GG 119 Road Safety Audit Response Report

Report Title	<i>Land at, Transvaal Terrace/Carlinghow Hill, Batley, WF17 0AA</i>	Stage of RSA	Stage 1
Date	<i>03/02/2020</i>	Scheme Ref No.	<i>16-1112</i>
Prepared By	Cora IHT	On behalf of:	Kirklees (Overseeing Organisation)

Figure 3.2: Transvaal Terrace/Carlinghow Hill Improvement

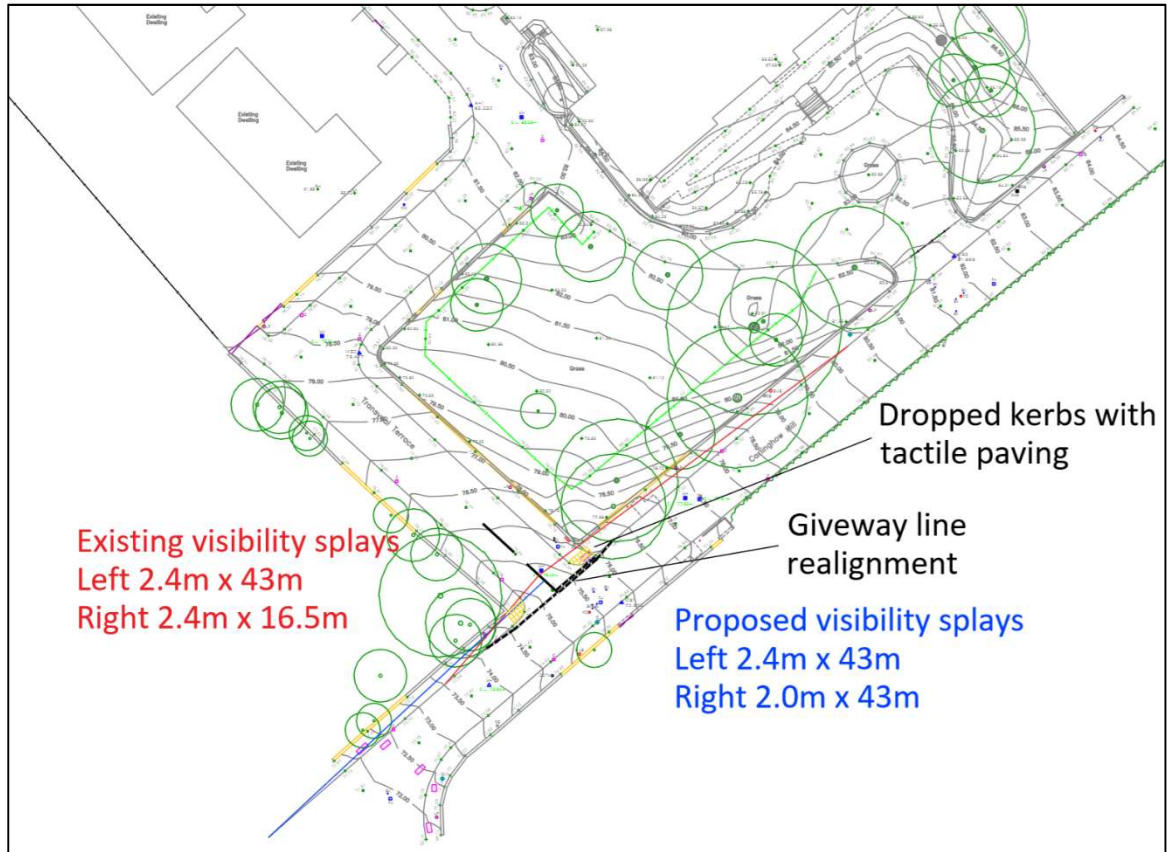
(1) RSA Problem	(2) RSA recommendation	(3) Design Organisation Response (see also Note 1)	(4) Overseeing Organisation Response	(5) Agreed RSA Action
<p>Problem No 1: Existing boundary walls and vegetation restrict visibility and increases the potential for a collision between a vehicle emerging from the development and traffic travelling along Carlinghow Hill.</p> <p>Location: Apartment access.</p> <p>Summary: Junction visibility splays at the secondary access serving the apartments are not indicated on the drawings provided and no vehicle speed data has been supplied to the Road Safety Audit Team. However, the existing boundary walls and vegetation to either side of the junction restrict visibility in both directions as shown within the images below. Insufficient junction visibility could lead to a collision between a vehicle emerging from the development and those travelling along Carlinghow Hill.</p>	<p>Recommendation: It is recommended that the current level of visibility is compared against the recommended level of visibility, applying Manual for Streets guidance, based on the results of a vehicle speed survey. Should the level of visibility prove to be substandard, it is recommended that the existing boundary wall and vegetation is removed and set to the rear of the visibility splay or access to the front of the apartments is taken via Transvaal Terrace to enable this access to be permanently closed.</p>	<p>Accepted Carlinghow Hill entrance for access only, with egress from the Transvaal Terrace junction.</p>

Figure 3.3: Housing Turning Head Tracking

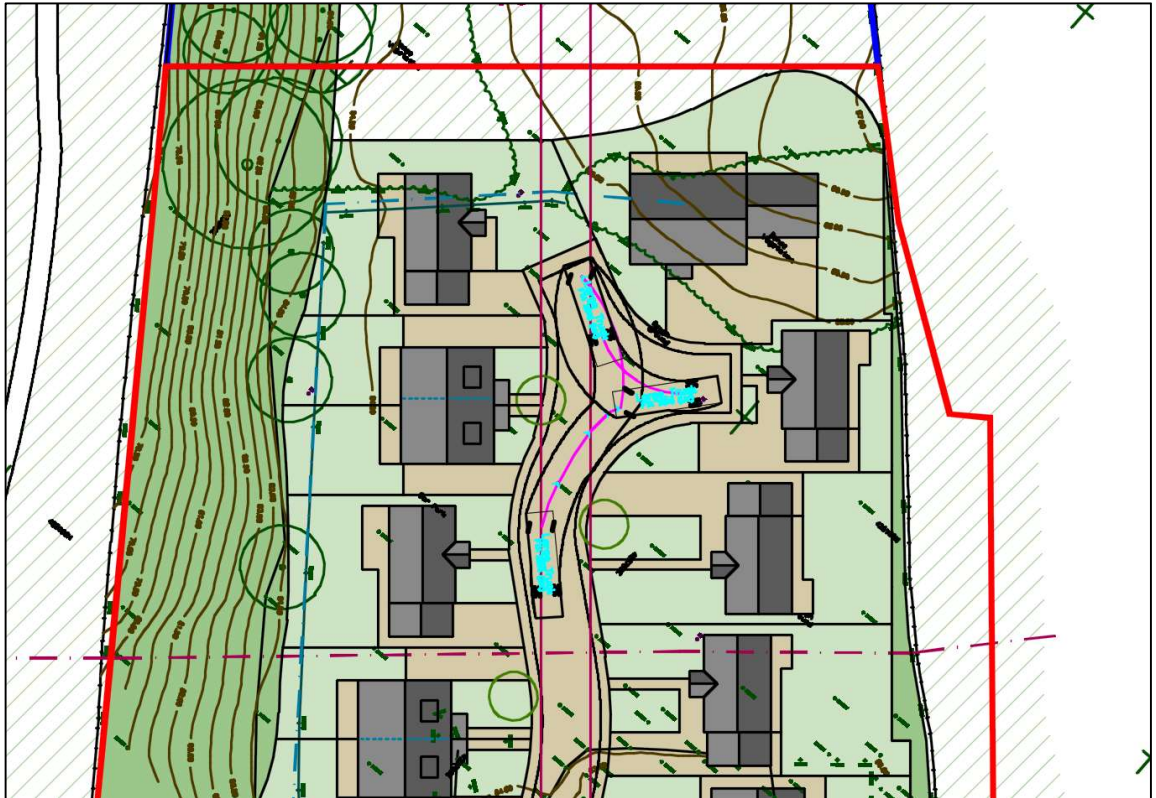
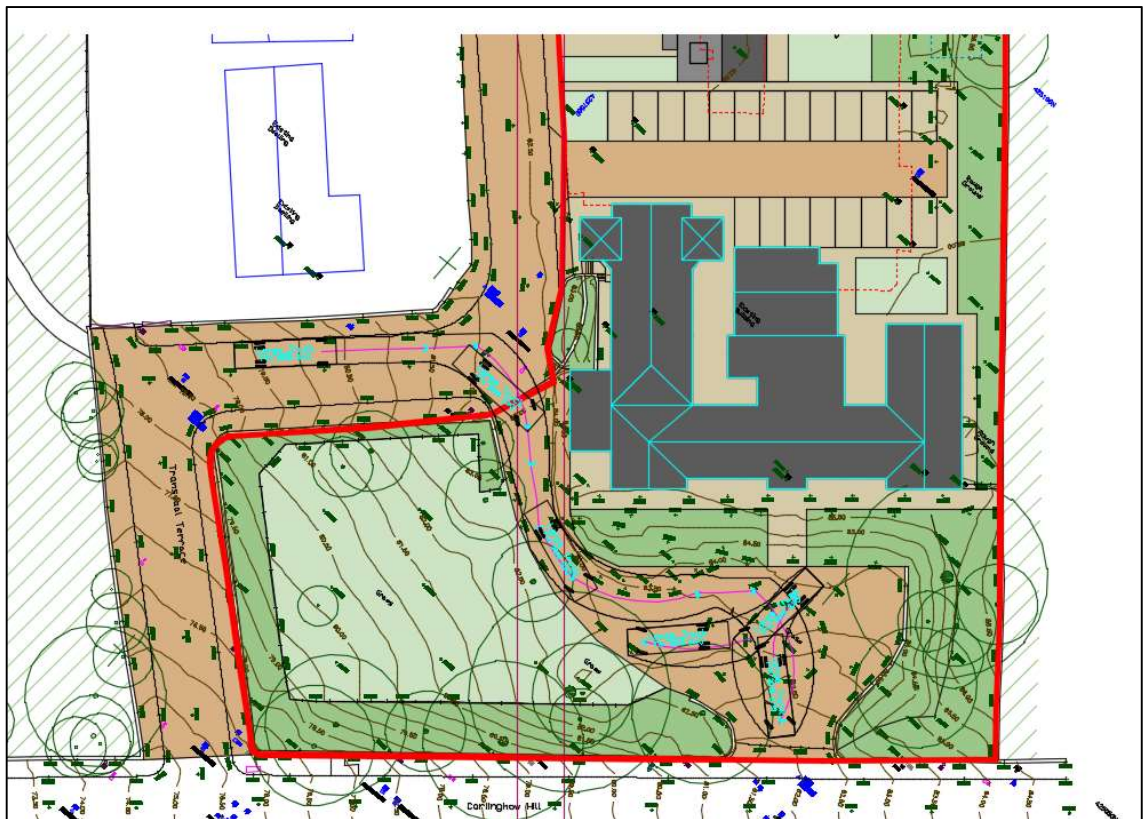
Problem No 2: The proposed turning facilities could result in the potential for a collision between a turning service vehicle and other road users.

Location: Proposed turning facilities.

Summary: The Transport Statement includes an extract of a swept path analysis using a 10m rigid vehicle turning within the apartment car park and the turning facility at the head of the cul-de-sac. Firstly, it is noted that the swept path analysis has been undertaken on an alternative layout fronting the apartments, which does not include 9 proposed car parking spaces, thereby reducing the available space. The swept path analysis has also been undertaken using a 10m rigid vehicle rather than a standard Kirklees refuse vehicle which is 11.85m in length. Based on the tracking exercise undertaken (which is not to a scale) it appears unlikely that this size of vehicle can enter and exit the development in a forward gear, leading to potential overrunning of driveways/margins/parking spaces or excessive reverse distances in conflict with other road users.

Recommendation: It is recommended that a swept path analysis of the proposed turning facilities is undertaken using a large refuse vehicle (specification included within the Kirklees Highway Design Guide SPD) and the turning areas are amended accordingly.

Disagree. The tracking in the TA has been superseded by tracking using 12m refuse vehicles submitting during the post submission consultation with Kirklees. These has now been agreed.
